Planning Application (Householder)

Application Number LU/261/15/HH

I would like to lodge my objection to the proposed "single storey rear extension" This involves the extension of the lower floor balcony by 1.0 metre – an 80% increase on the present balcony width and 100% on its length.

SITE / BLOCK PLAN
1:200

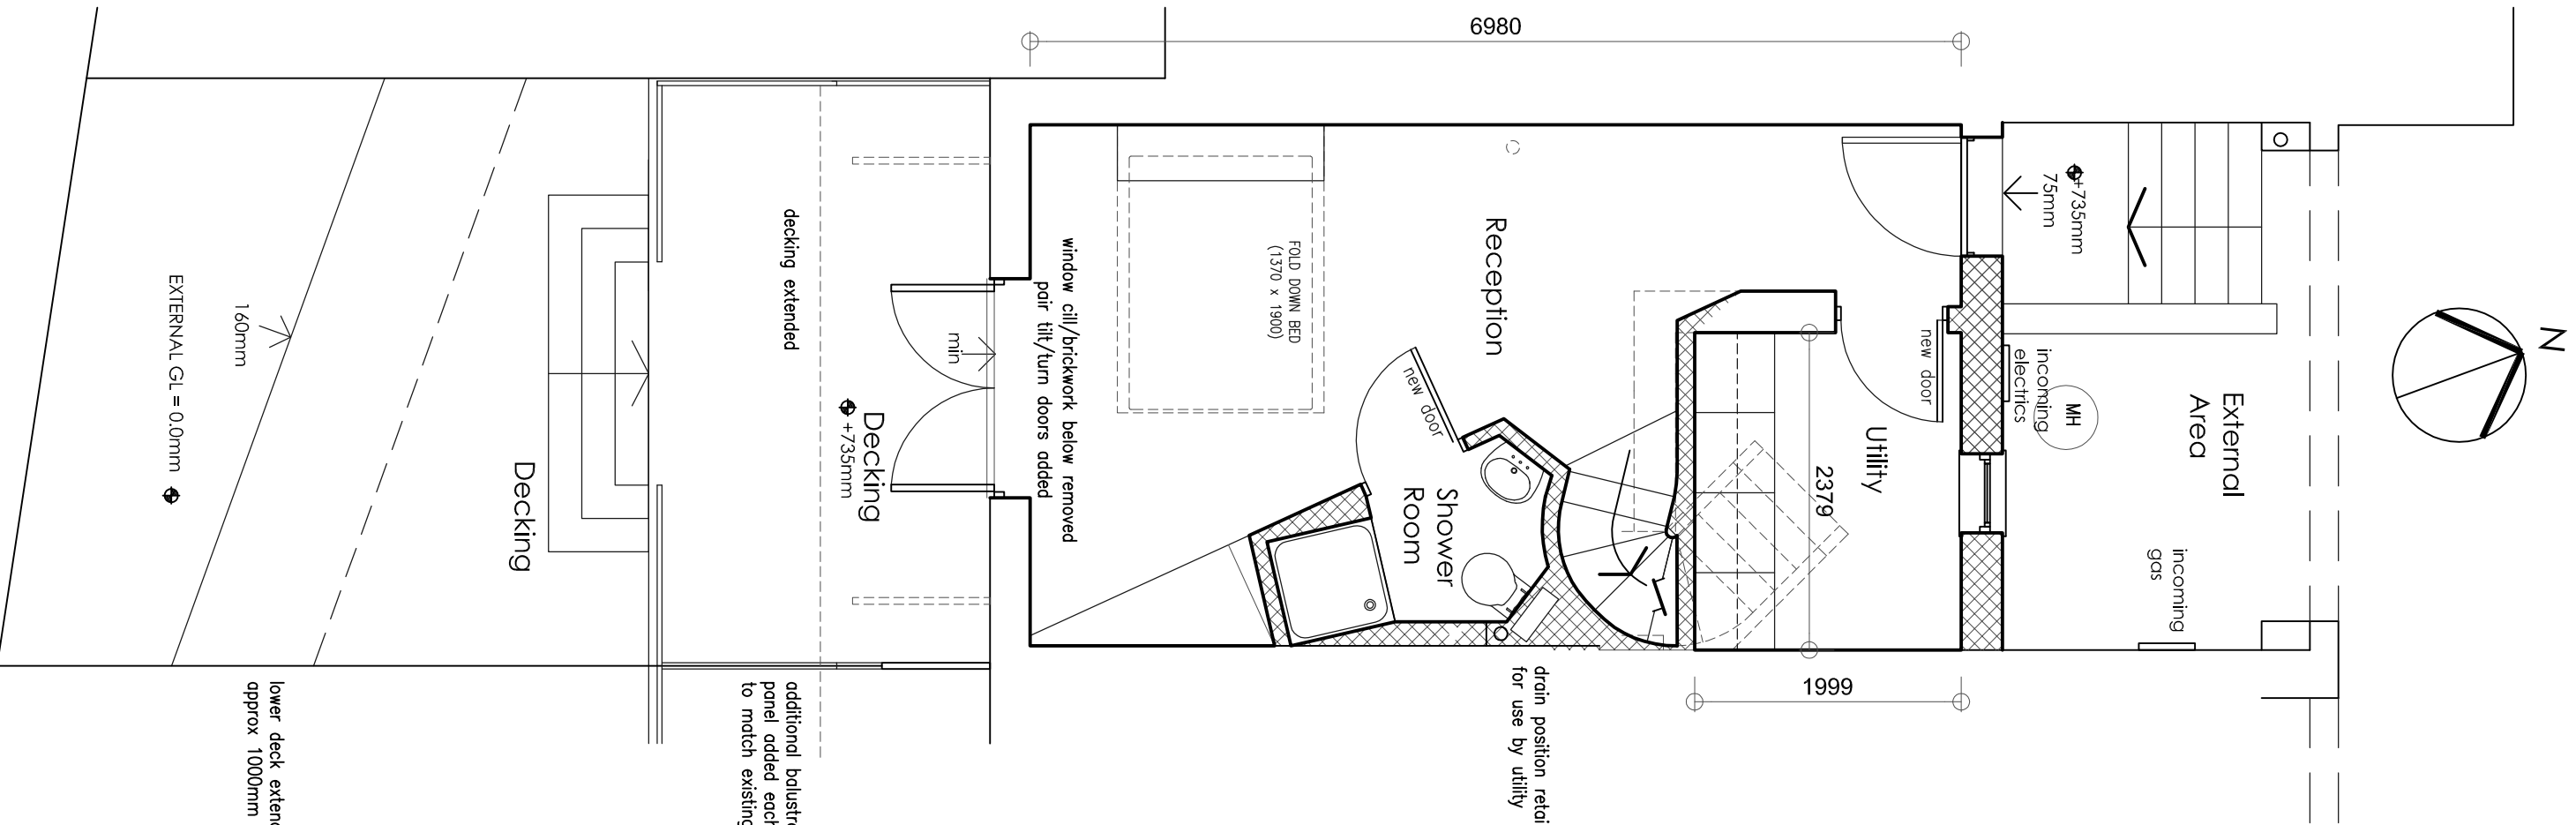
Secondly, the extension would overlook adjacent gardens from the 0.75 high balcony extension. This would adversely affect our privacy.
